BLACKTOWN HOSPITAL REDEVELOPMENT STAGE 2 – RESPONSE TO SUBMISSIONS

The Environmental Impact Statement (EIS) for the Blacktown Hospital Redevelopment Stage 2 (SSD 7058) was publicly exhibited between 5 November 2015 and 4 December 2015.

SCALE:
1:1000
DRAWING No.
SSD-AR-DG-0121

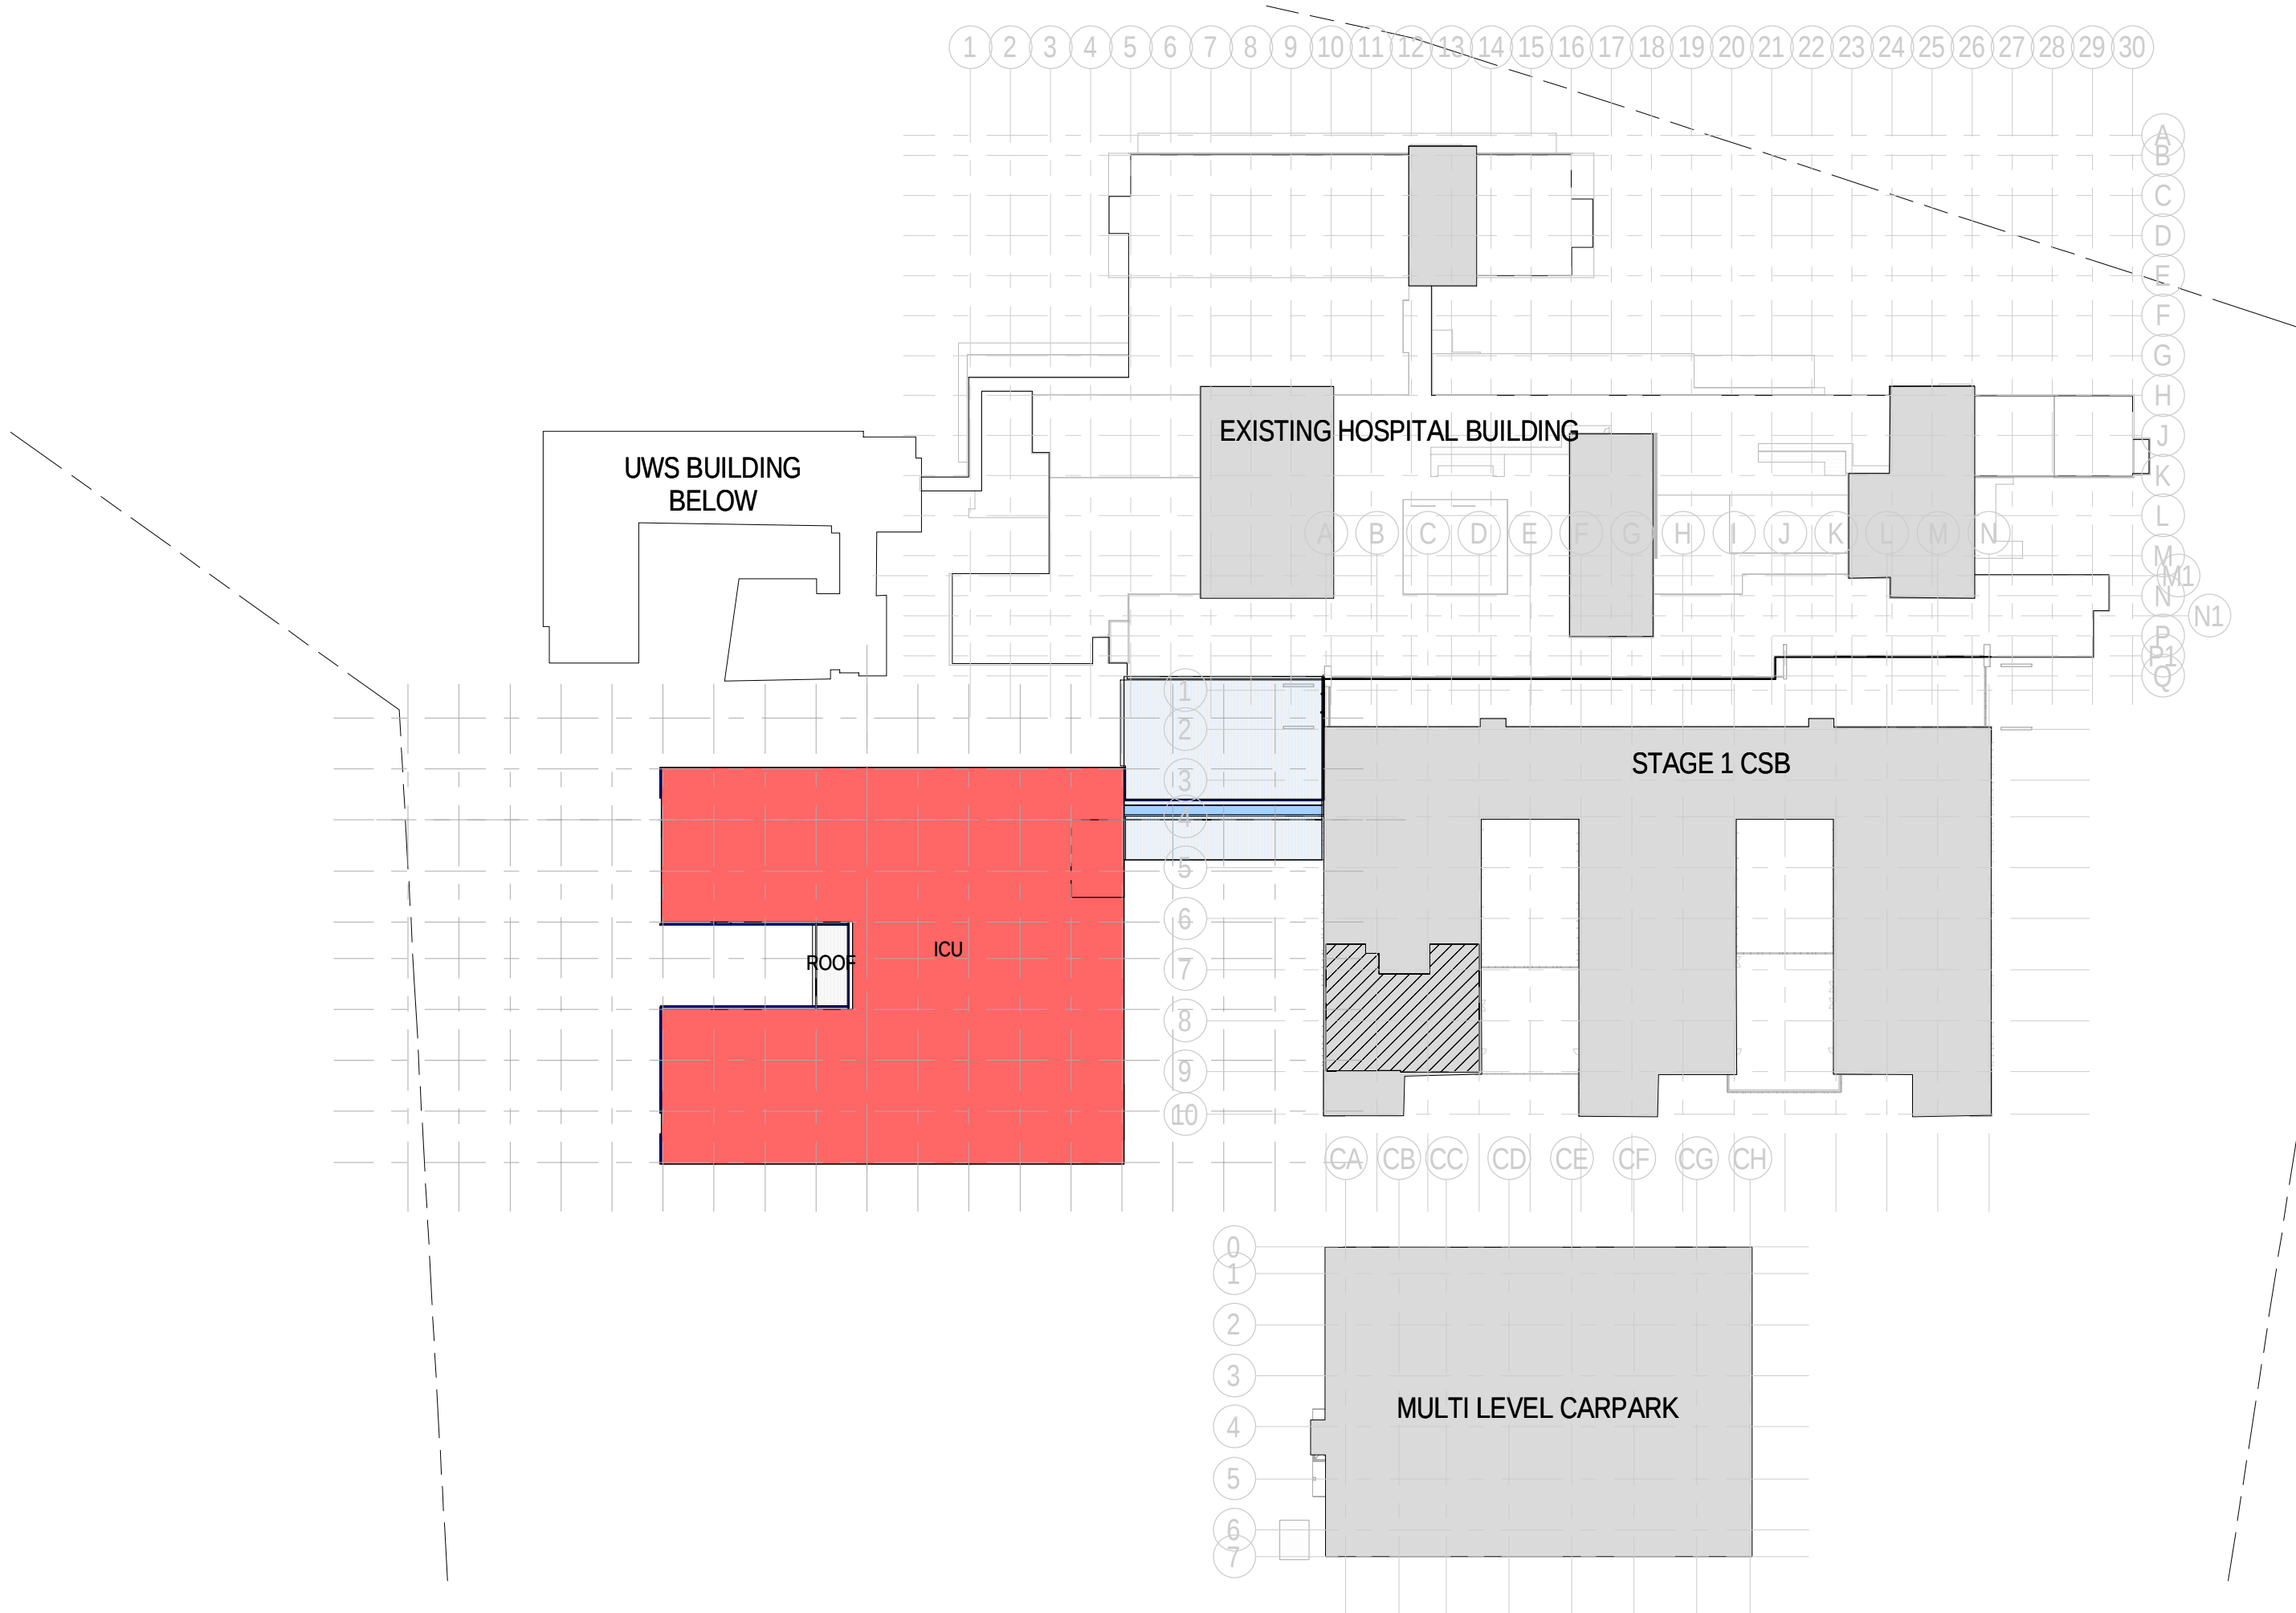
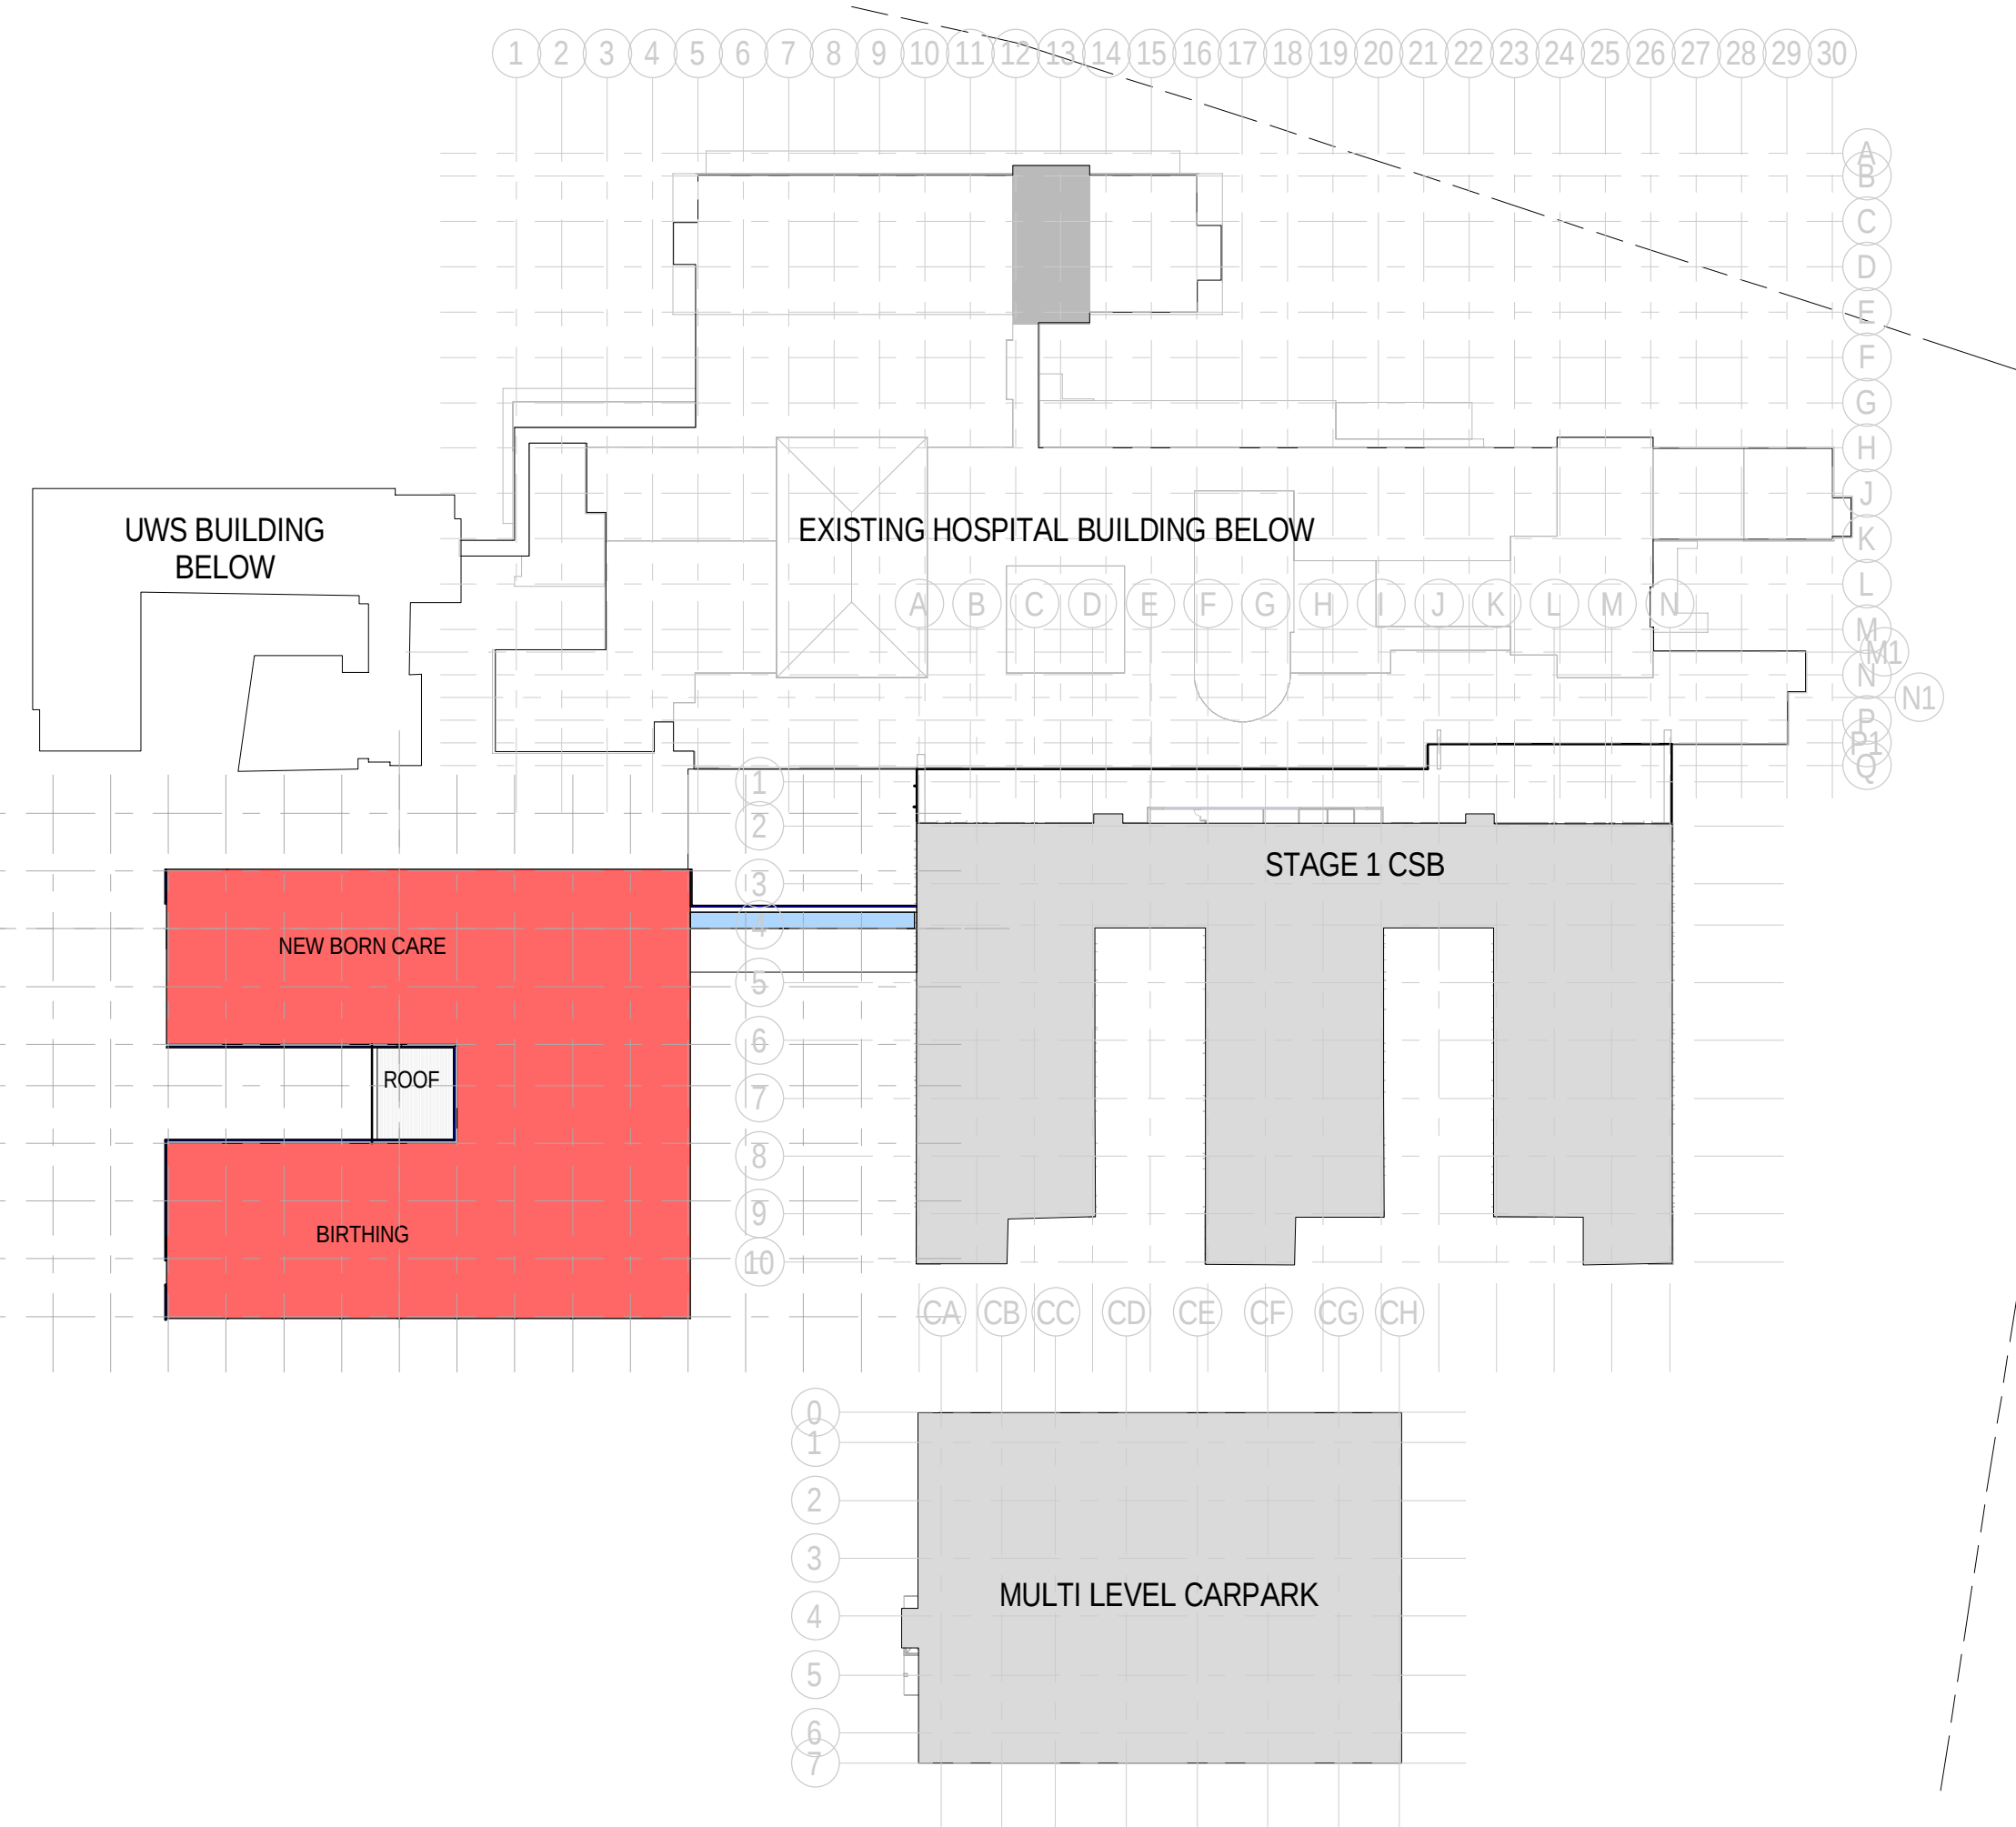
As a result of continued concept development and a better understanding of the functional needs of the facility a minor change as been made to the proposed envelope and massing. The tower elements have been reorientated to align east / west rather than north / south. The proposed changes will result in better functional relationships and ESD outcomes, and an improved outlook for patients.

Whilst the building footprint and envelope remain largely unchanged, the height of the building has been reduced. As shown on the updated plans attached, the height of the podium is the same, however the overall height of the building has been reduced to 9 storeys (including plant) from the originally proposed 10 storeys. As demonstrated in the revised shadow and massing diagrams, the changes to the envelope will not result in any additional shadow or view impacts.
